Able Marine Energy Park

Material Change 2

Statement of Common Ground

ABLE HUMBER PORTS LIMITED

DO NOT SCALE

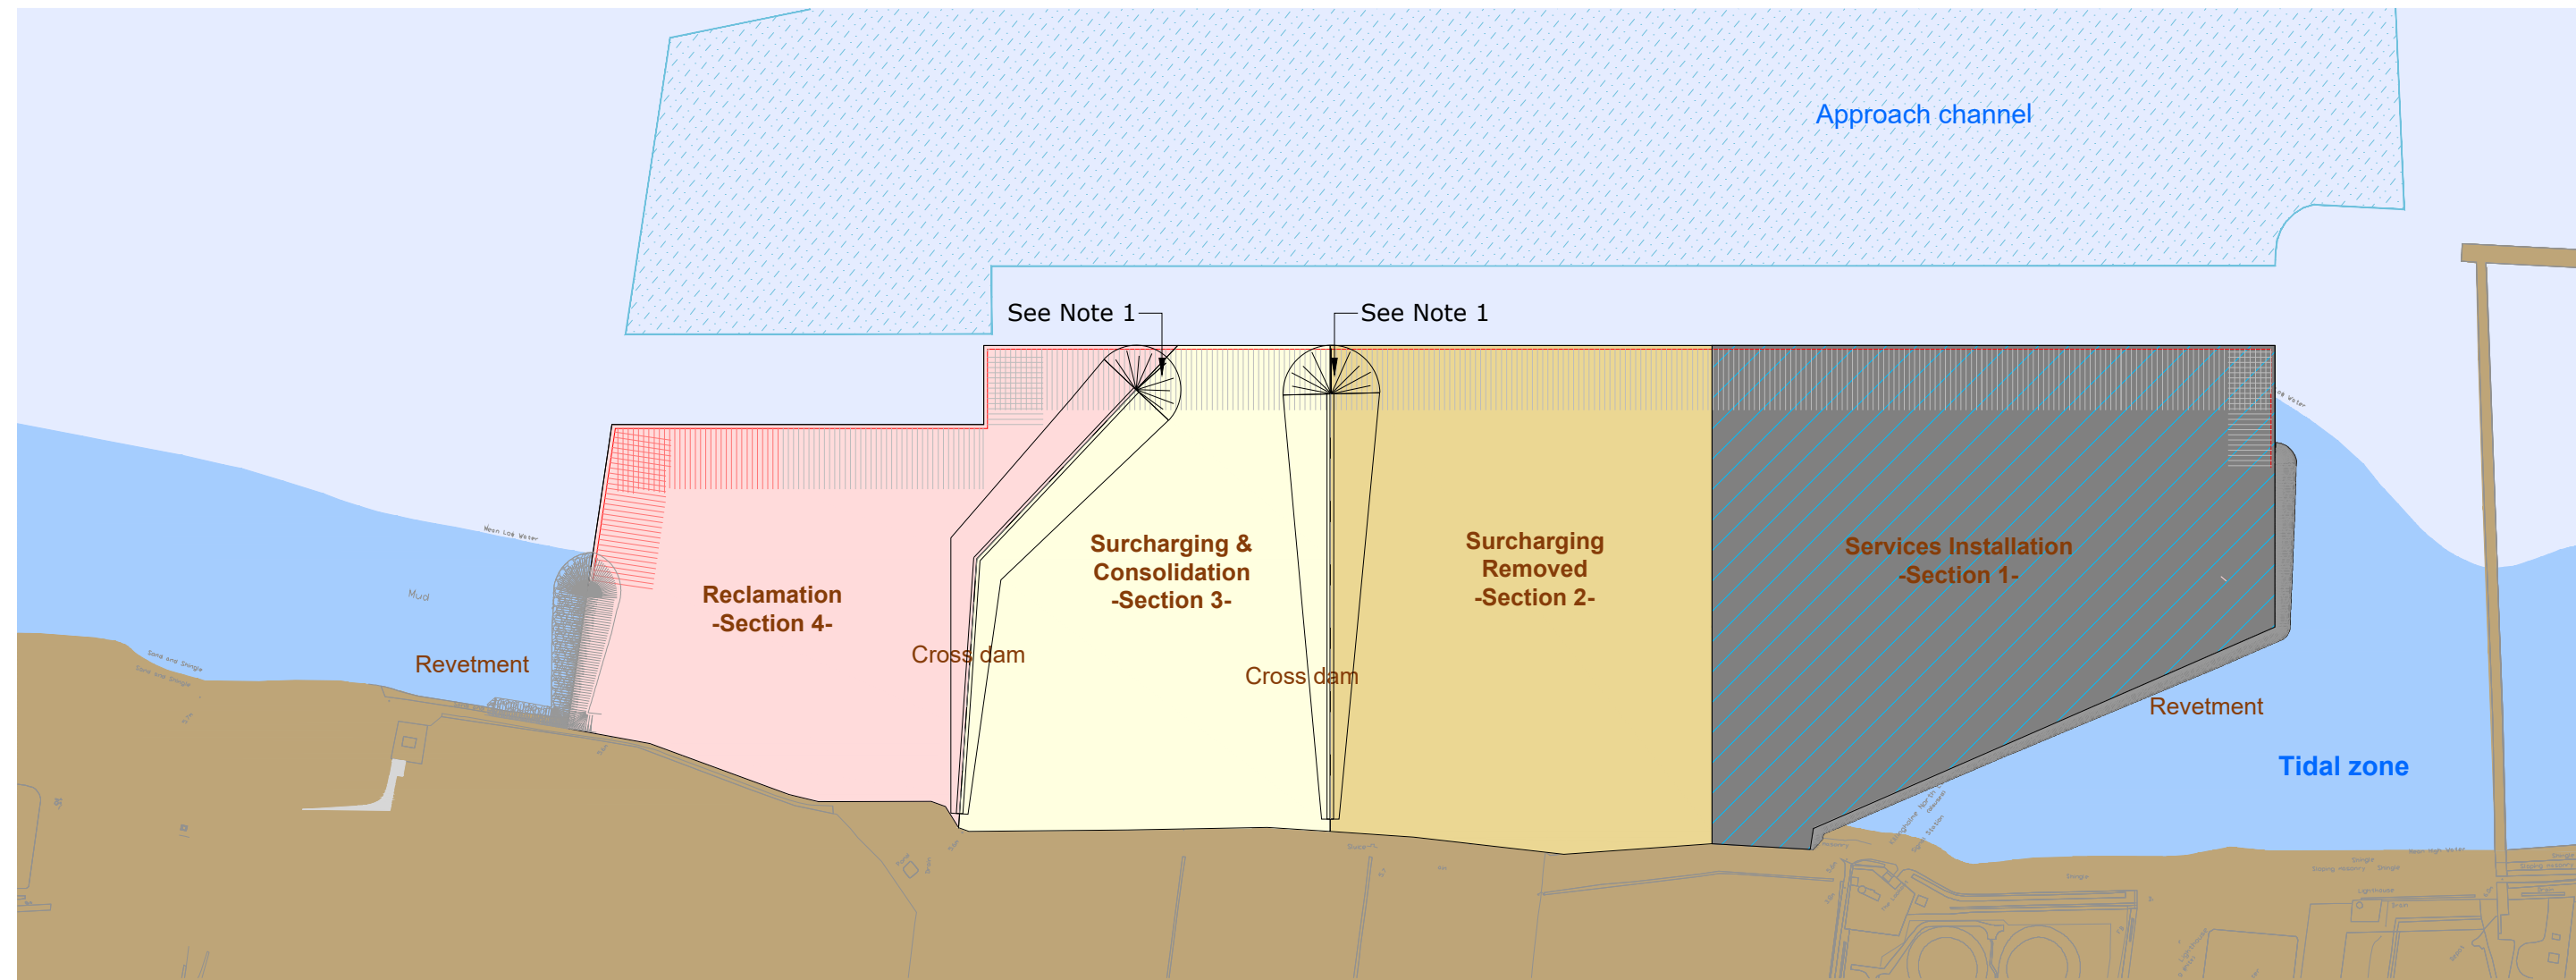
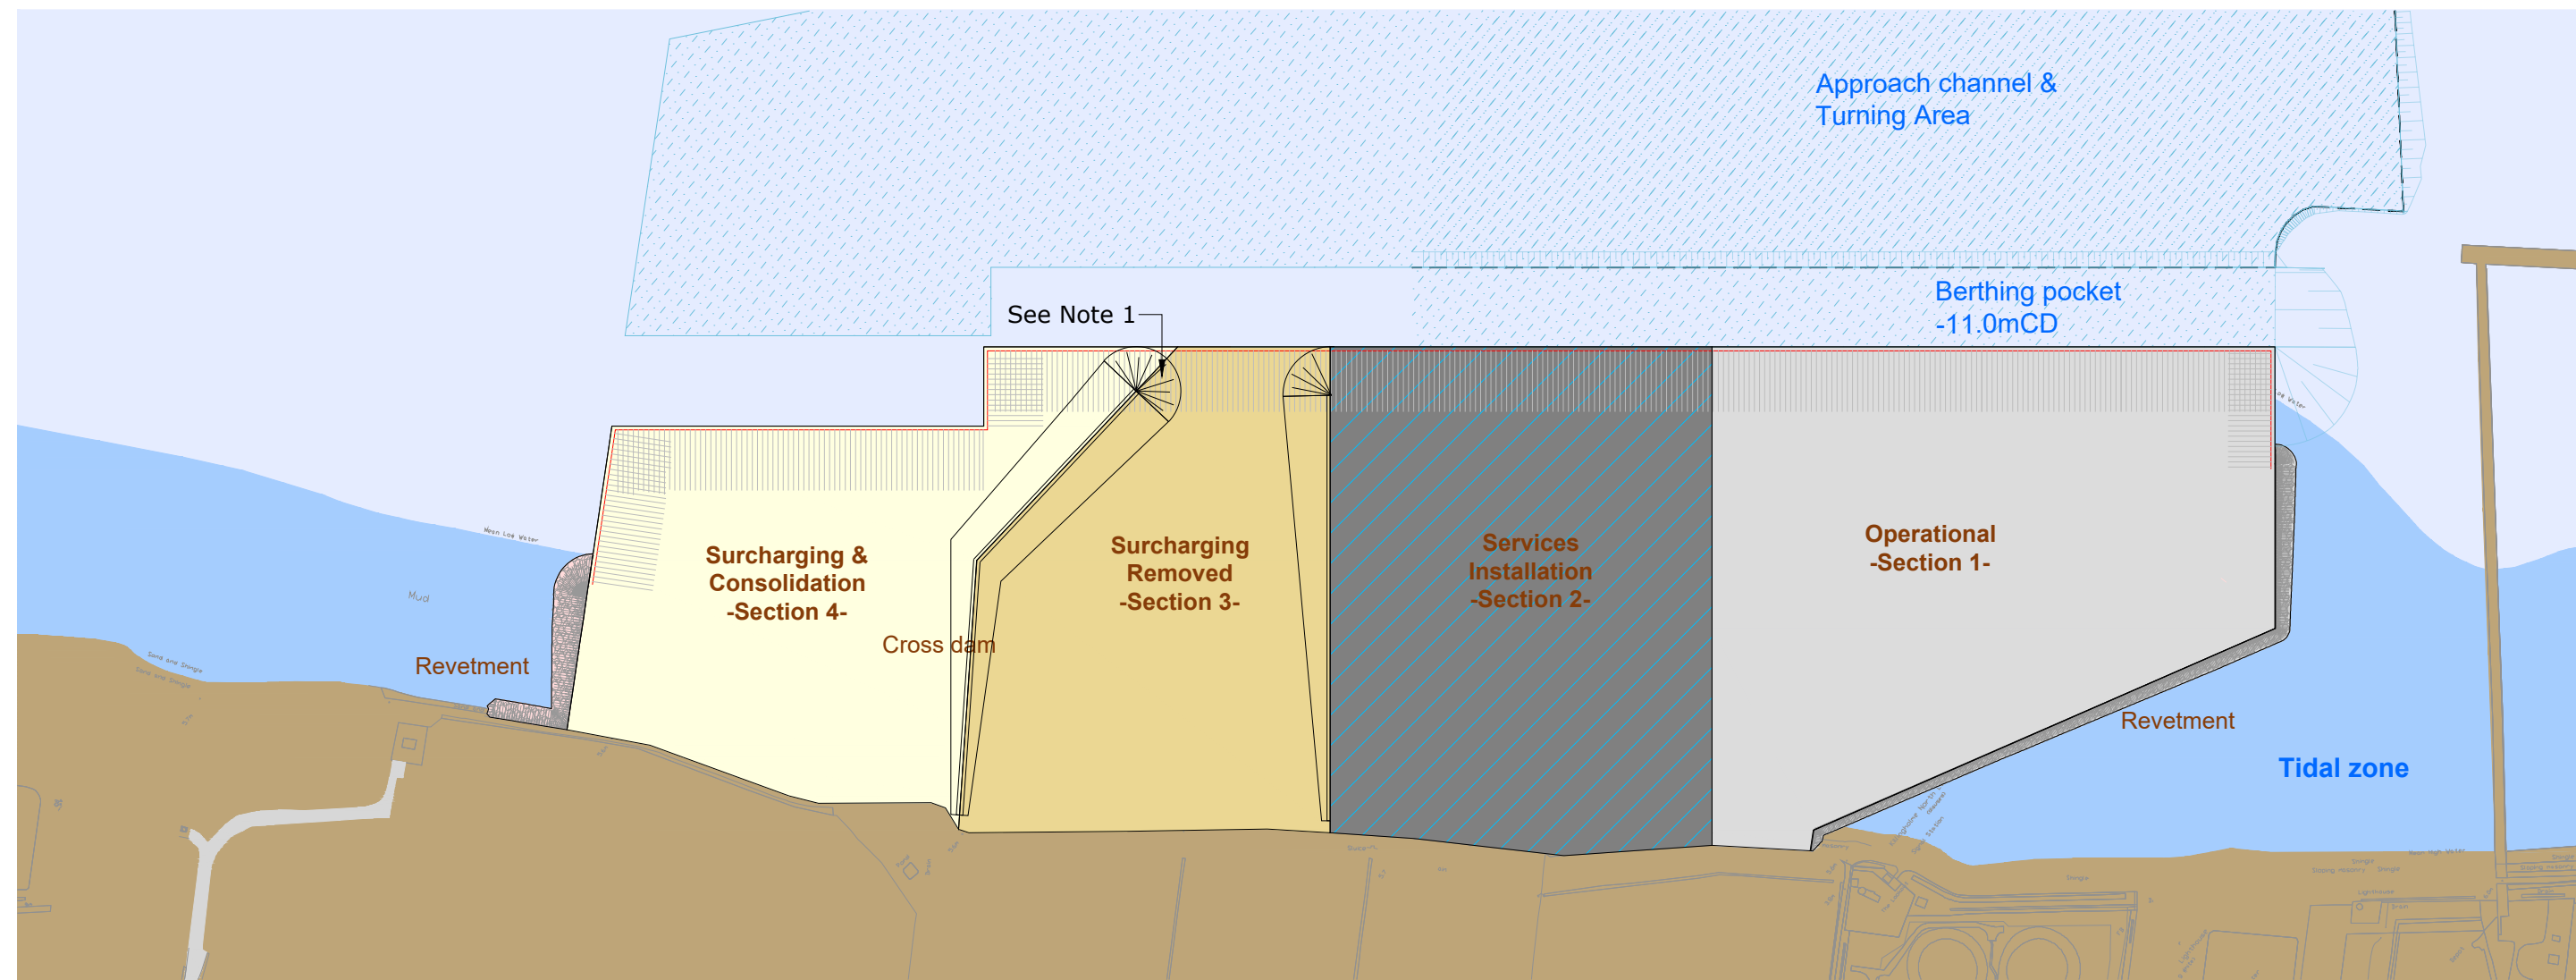
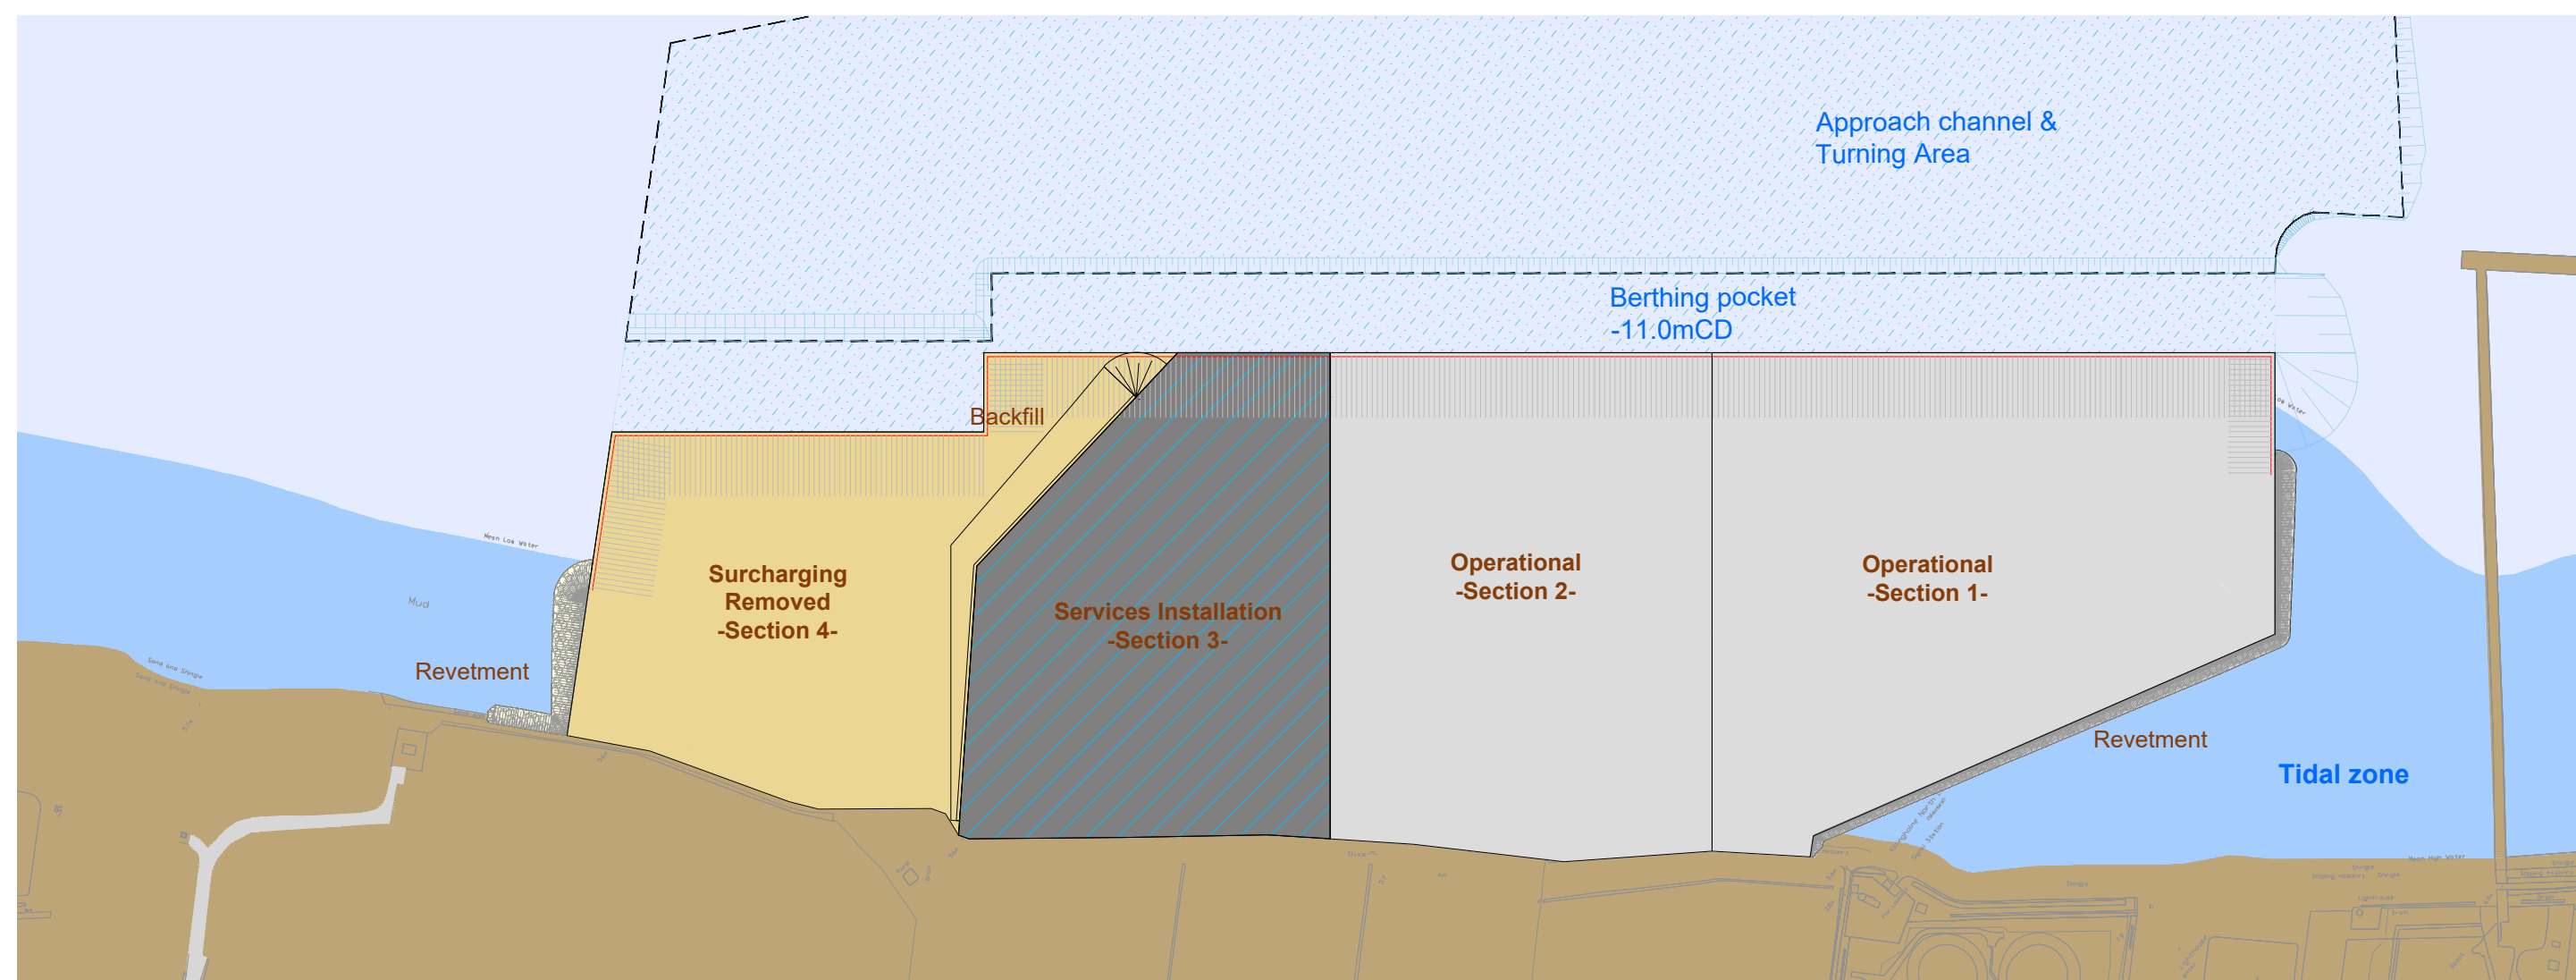
- 3.7 An additional submission has since been made by the Applicant in respect of the draft DCO Amendment Order to further amend two of the construction sequencing design drawings. The Applicant has submitted drawings AME-036-10009 (Rev D) and AME-036-10010 (Rev D) to the Planning Inspectorate, together with an amended draft Amendment Order which would permit the Applicant to follow either the construction sequencing drawings previously submitted (AME-036-10009 (Rev C) and AME-036-10010 (Rev C)) or the amended versions.

- 3.8 The original construction sequence was to build the quay from north to south; the material change proposes reversing this to build the quay from south to north. A variation on both of these has been proposed, namely building the revetment at the north first, and then building the quay from south to north, starting with a revetment at the south. This would mean that the specialist equipment needed to build the revetments would only need to be mobilised and used for one period at the start rather than being re-mobilised to build the northern revetment later.

- 3.9 The parties note that AME-036-10009 (Rev D) and AME-036-10010 (Rev D) have not yet been published on the Planning Inspectorate website. The Applicant has discussed the amended drawings with C.Ro and C.Ro has no immediate concerns regarding the proposed changes. Nevertheless, C.Ro reserves the right to make further representations once the documents have been published and it has had the opportunity to review them in detail.
